SEEGER HOMES INC. - SALES OFFICE

SITE DEVELOPMENT PLANS
LOT 3, APPALOOSA HIGHWAY 24 SUBDIVISION

SALES OFFICE - SPECIAL USE
DEVELOPMENT PLAN

SHEET NO. C-01
DATE: 05/25/18
PAGE NO. 1 OF 1

SALES OFFICE - SPECIAL USE
SITE PLAN

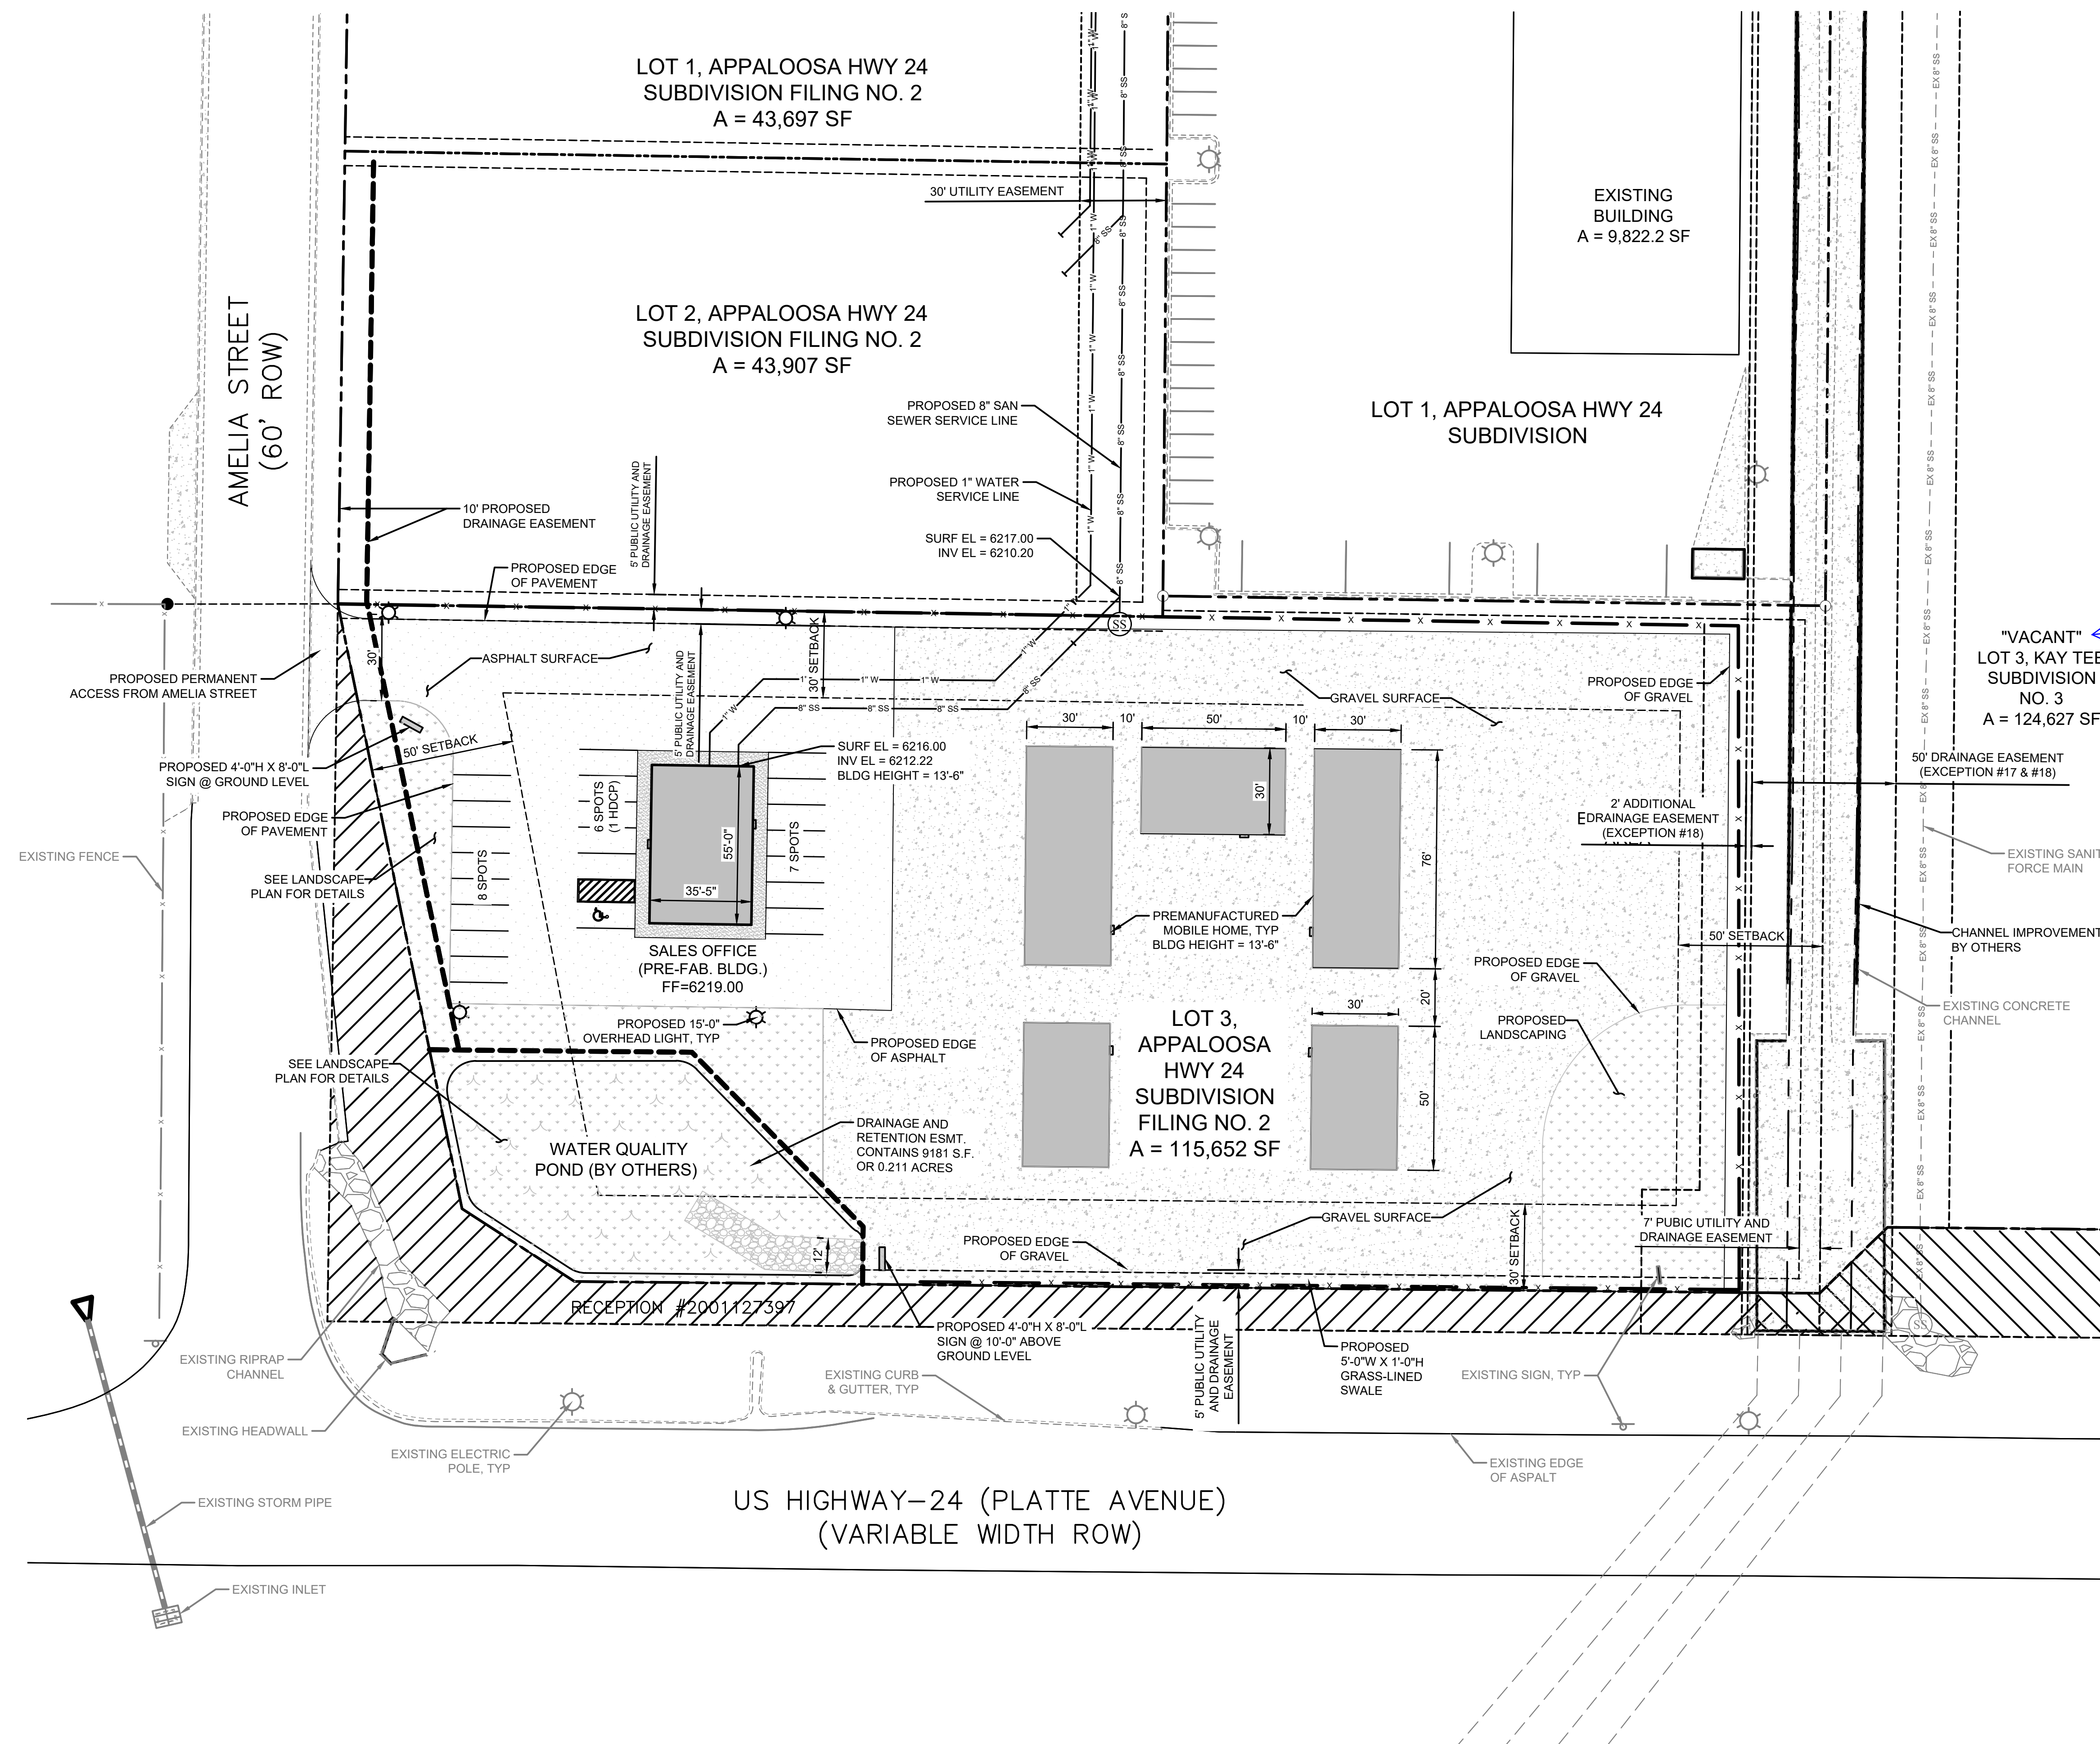
Please note that CO will not be given to the sales office until the channel improvements and the water quality pond have been completed.

Identify all adjacent property owners by owner of plat name.

Move the proposed sign outside of the ROW.

Is this equipment yard temporary or permanent? Address this in your letter of intent.

This area must comply with the Outside Storage standards in Chapter 5.2.38 of the El Paso County Land Development Code.

Does this entire area need to be gravel? Can you leave some vegetative cover (per the four step process that needs to be addressed in the drainage report)?

Be sure that the sign is outside of the public ROW.

Add PCD file no. AL1811

Add "improvements to channel by others"

20' height max in a parking lot.
